**KIRKLEES METROPOLITAN COUNCIL
INVESTMENT & REGENERATION SERVICE**

DELEGATED DECISION TO DETERMINE PLANNING APPLICATIONS

Reference No:	2026/62/90371/W
Site Address:	5, St Mary's Road, Honley, Holmfirth, HD9 6BQ
Description:	Erection of single storey side extension (within a Conservation Area)
Recommending Officer:	Joshua Merriman

Officer Report – 2026/90371

Project	Proposed single storey side extension at St Mary's Road, Honley
Client	Mrs A Gould, 5 St Mary's Road, Honley HD9 6BQ
Dwg Title	(25426)2_Scheme as proposed
Scale	1: 50, 100, 200 @ A1
Date	Feb 26

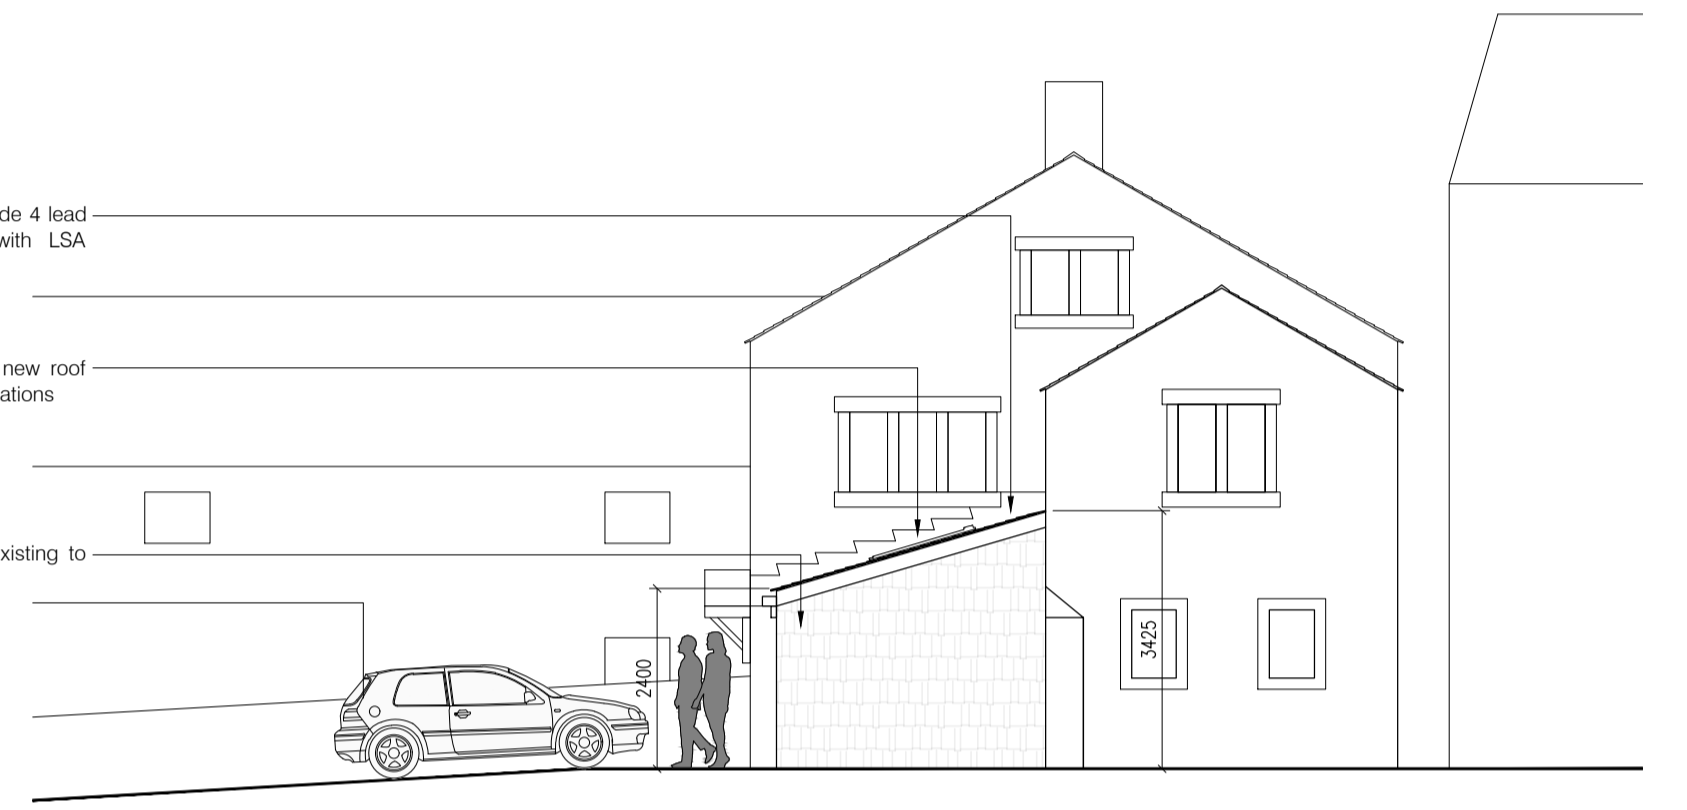
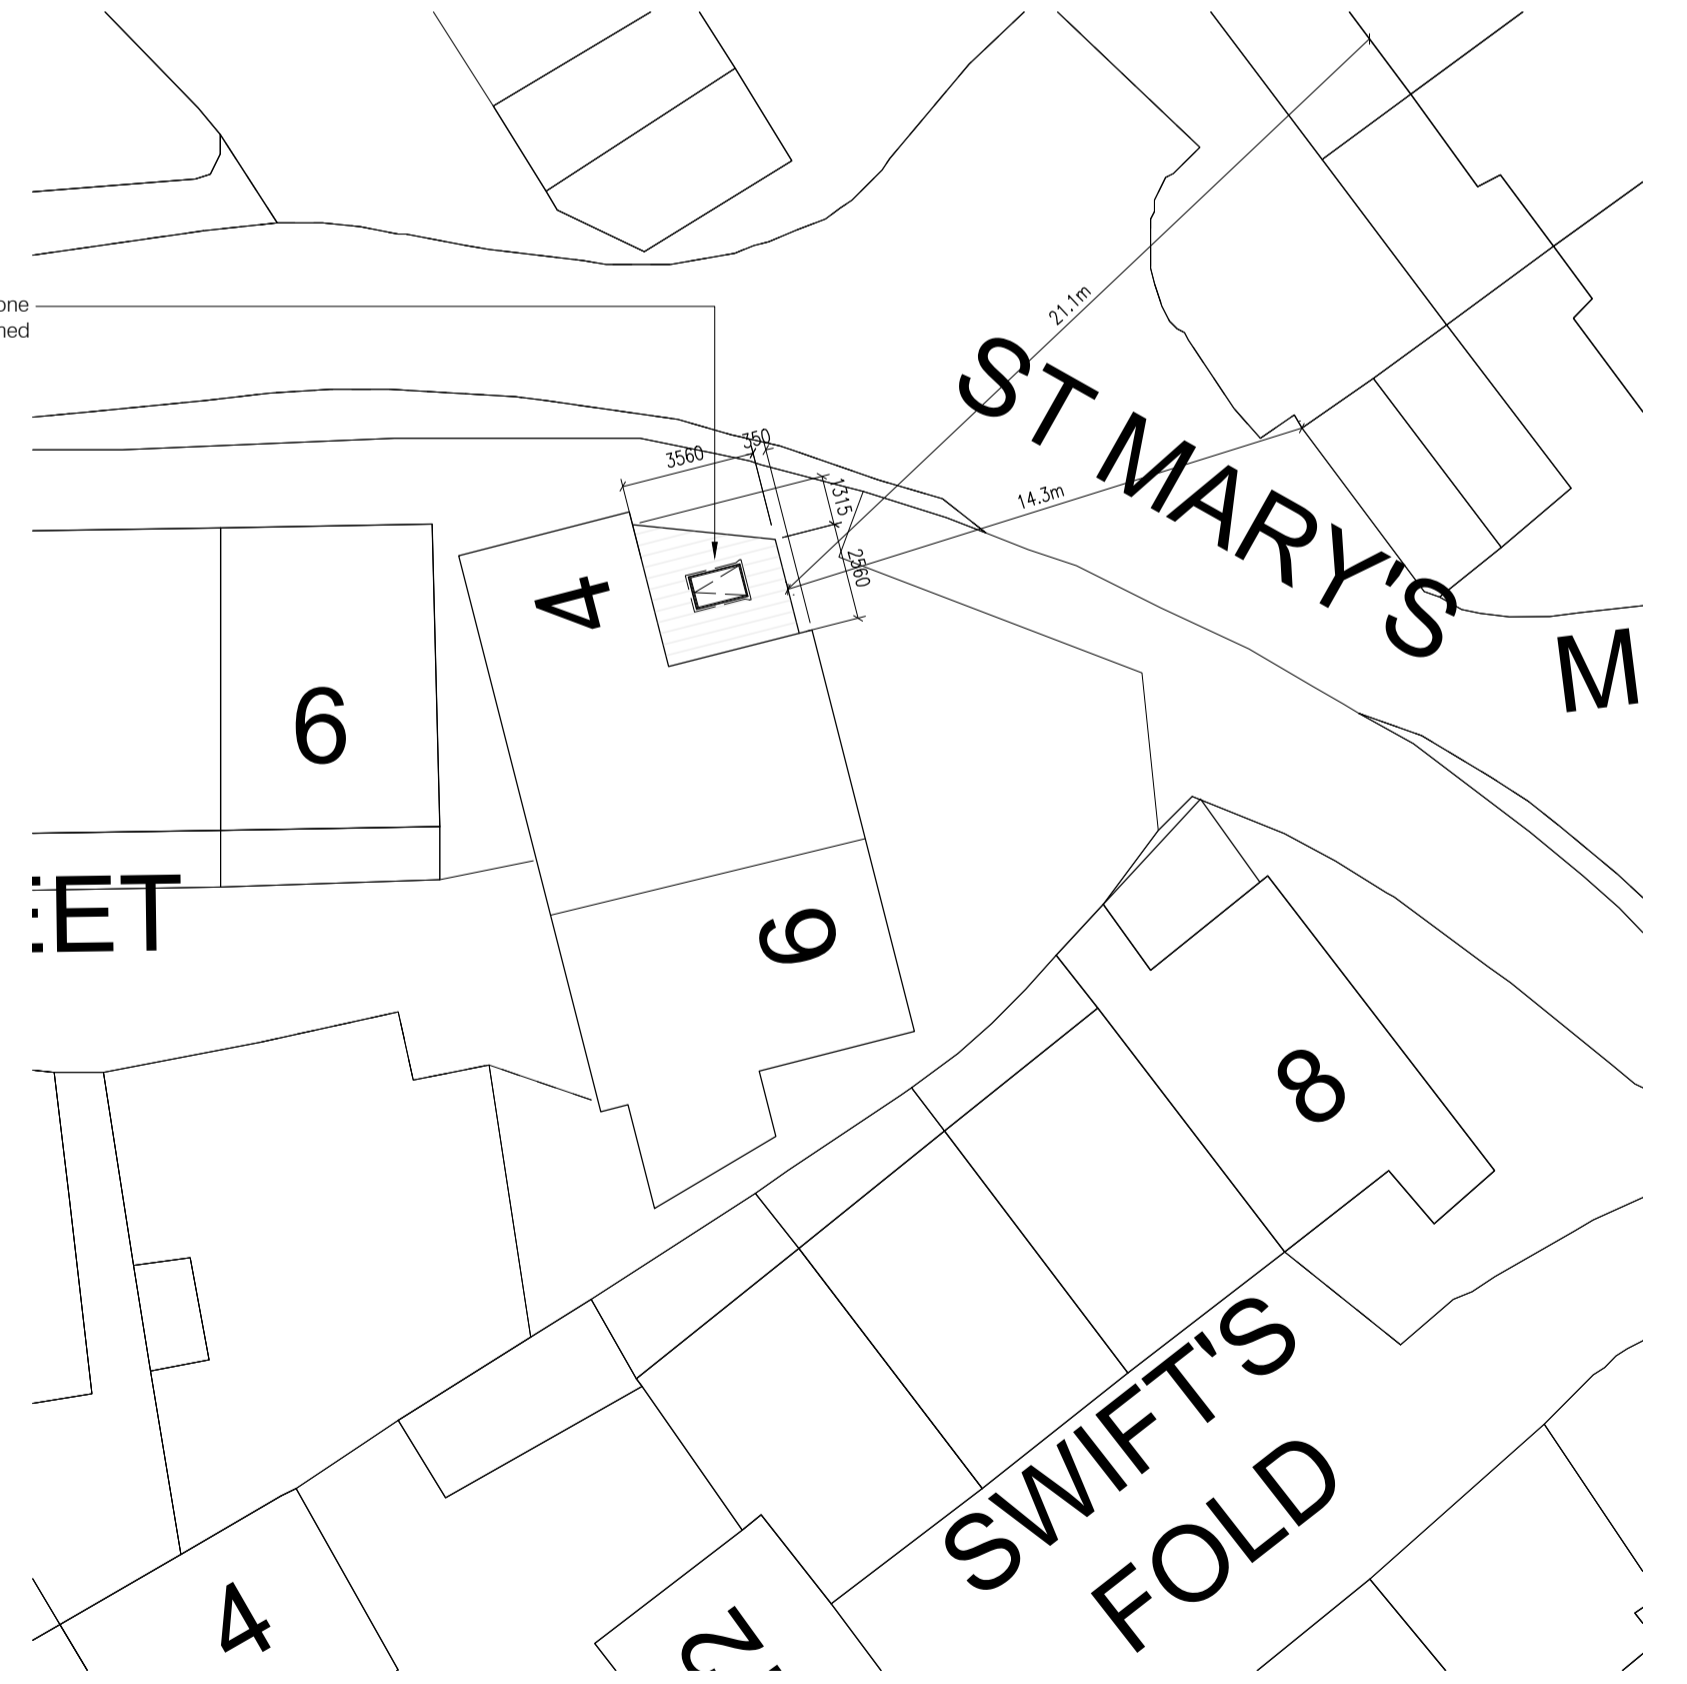
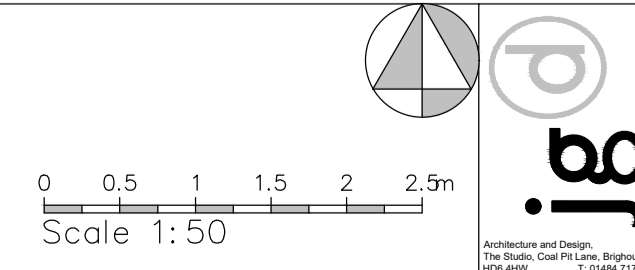
The proposed extension is considered to have a minimal impact on the local character of the area due to its subservient design in relation to the host property, and use of materials to match the existing building, including coursed natural stone and stone slates, with the use of green oak frame windows which are also considered to appear sympathetic. Furthermore, the extension does not extend further than two thirds of the original house, and does not exceed a height of 4m.

Although the extension is set back only 350mm from the front elevation of the existing dwelling rather than 500mm set out by the SPD, it is considered that this still allows for a visual break and is acceptable as a result.
